**Pemulwuy Mixed Used Development (MP11_0093-Mod-3)
Request for Additional Information**

I refer to the request to modify the development consent for Pemulwuy Mixed Used Development (MP11_0093-Mod-3) for internal and external design changes to Precinct 2.

JOB No	DE100210
DATE	June 2010
SCALE	A1 @ As indicated
DWG No	2DA200 E

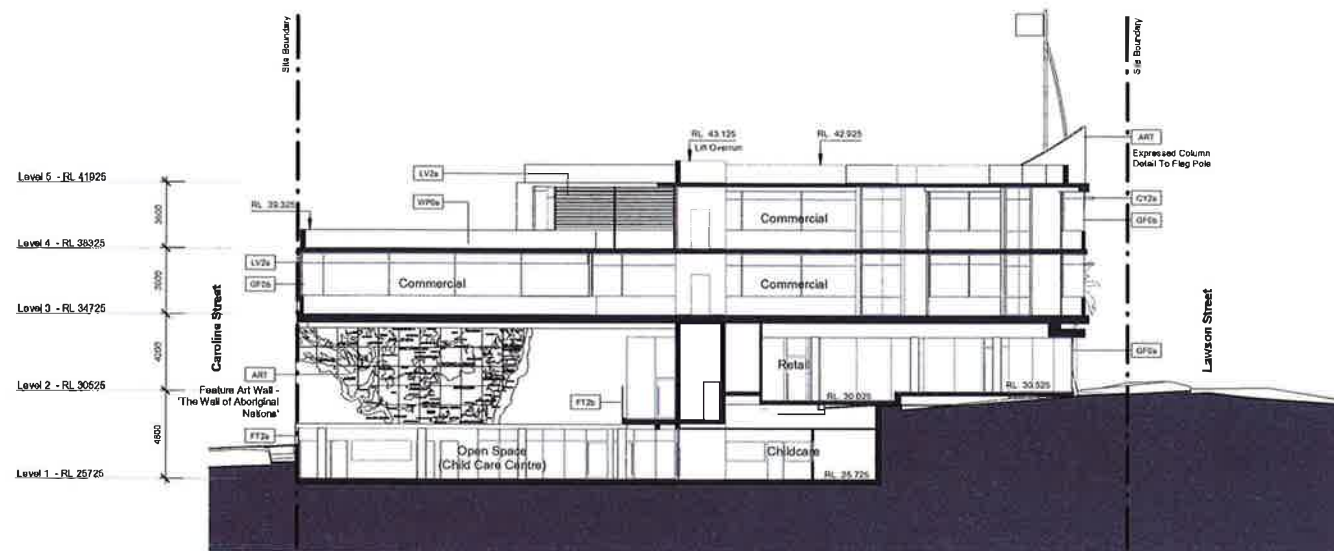
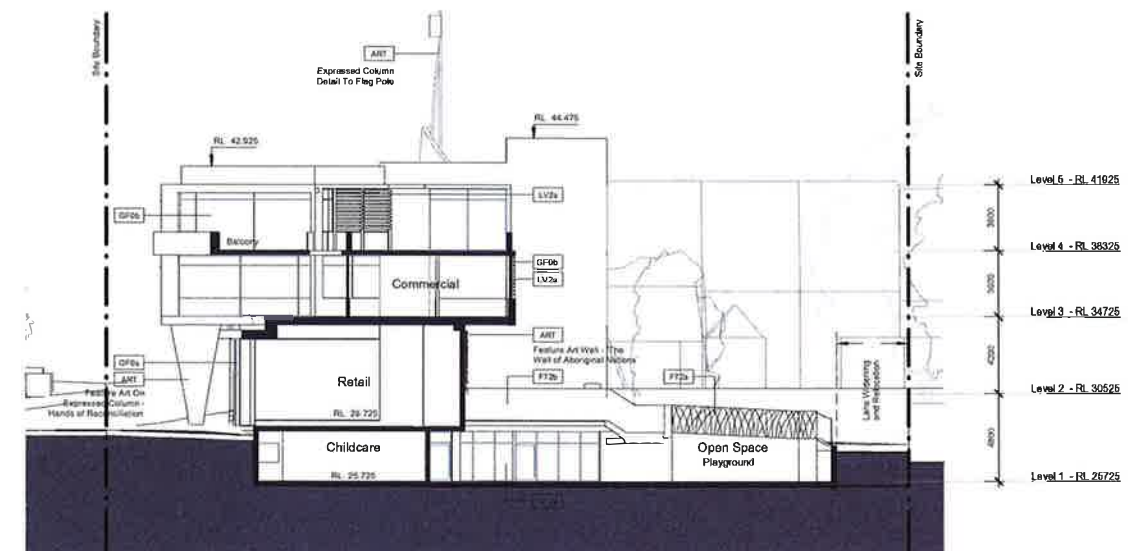
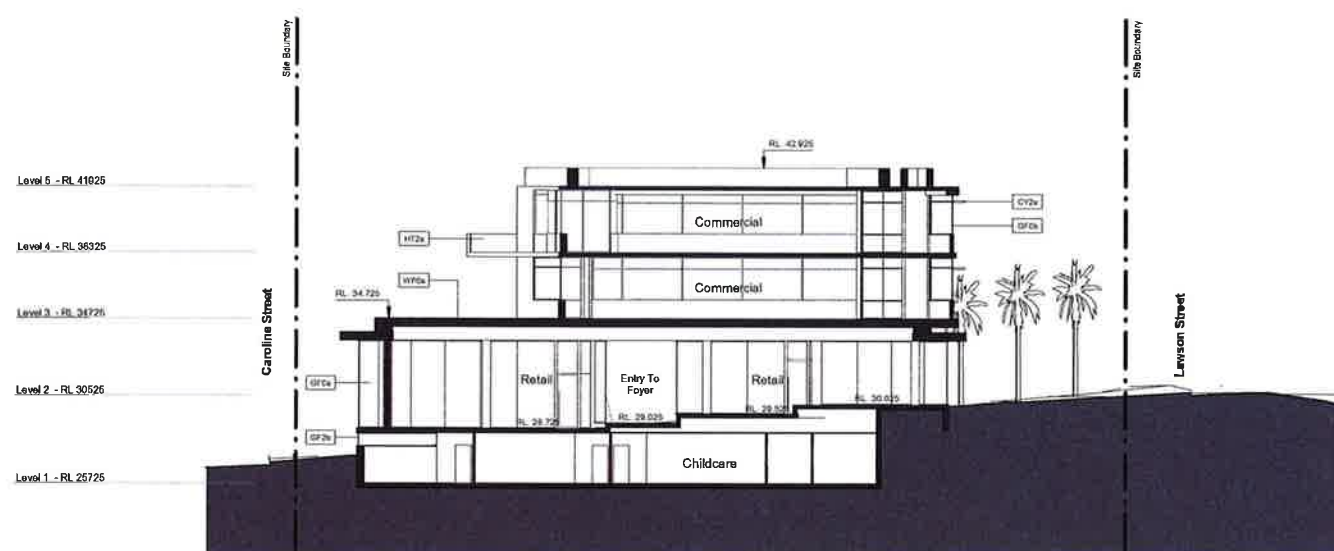
Acoustic barrier

- Submit amended plan 2DA200M, Sections, Rev M dated 11/08/20 with the updated treatment to the acoustic wall
